**Consultation Response from KC,
Highways Development Management****2024/92808 Popeley Farm, Muffit Lane, Gomersal, Cleckheaton, BD19 4QS****Prior notification for change of use from agricultural building to 3 dwellings****Date Responded: 13/11/2024.****Responding Officer: D. Stainsby****Responding Ref: K9-12NE/4****RECOMMENDATION:**

client:	Knabbs Ash Barn Ltd		
project:	Class Q Planning Application		
location:	Popely Farm, Muffit Lane, Gomersal BD19 4QS		
drawing title:	Site Plan Unit B As Proposed		
date:	31/07/23	drawn: jszn	scale @ A3: 1:500
			Job no: 23.111
drawing no:	1206	revision:	-

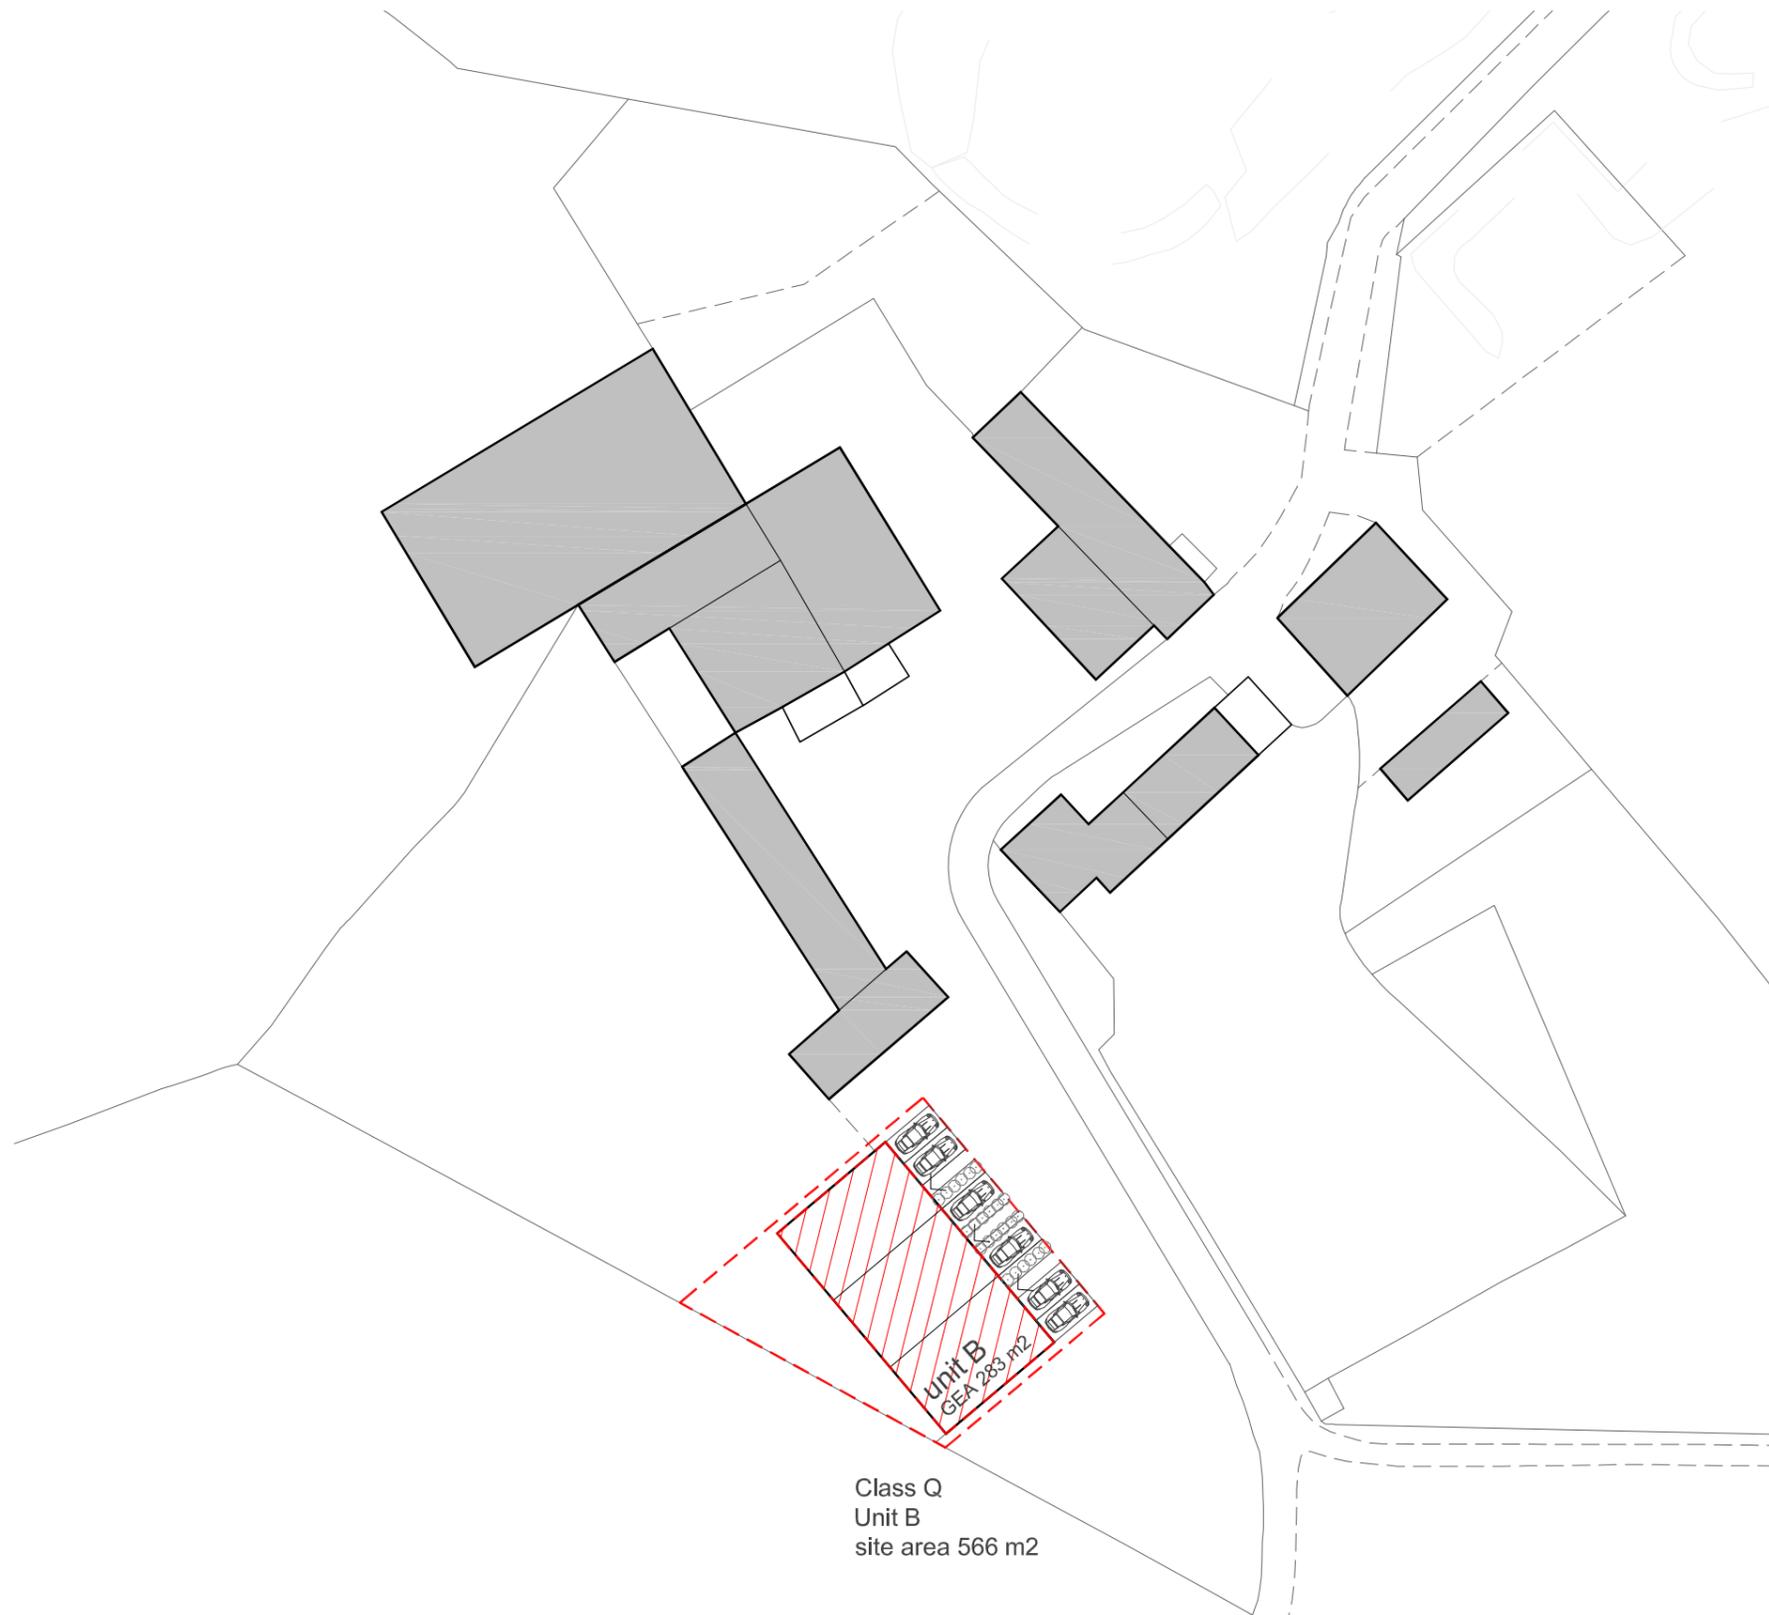
The site is currently accessed via a private drive and confirmation of the total number of dwellings on the site (both existing and proposed) is required to determine if the private drive requires laying out to an adoptable standard.

The driveway to the proposed dwellings is longer than 20m and the emergency access requirements require that the minimum width of the driveway would need to be 3.7m for its full length.

A turning area for fire tenders is also required when the route is longer than 20m.

A swept path analysis to show that a Kirklees fire service vehicle can both access and turn within the site in the case of an emergency needs to be provided.

The bin stores are over the minimum carry distance for the refuse collectors and as such a bin collection/presentation point should be located adjacent to the public highway.

The bin collection/presentation point must not obstruct the adopted highway or the driveway.

Details of the waste collection for the proposed dwelling should be provided, with the location of a waste collection presentation point being clearly marked on a drawing in such a location that is easily accessible to the collection team and where it will not obstruct the access or the adopted highway for road safety reasons.
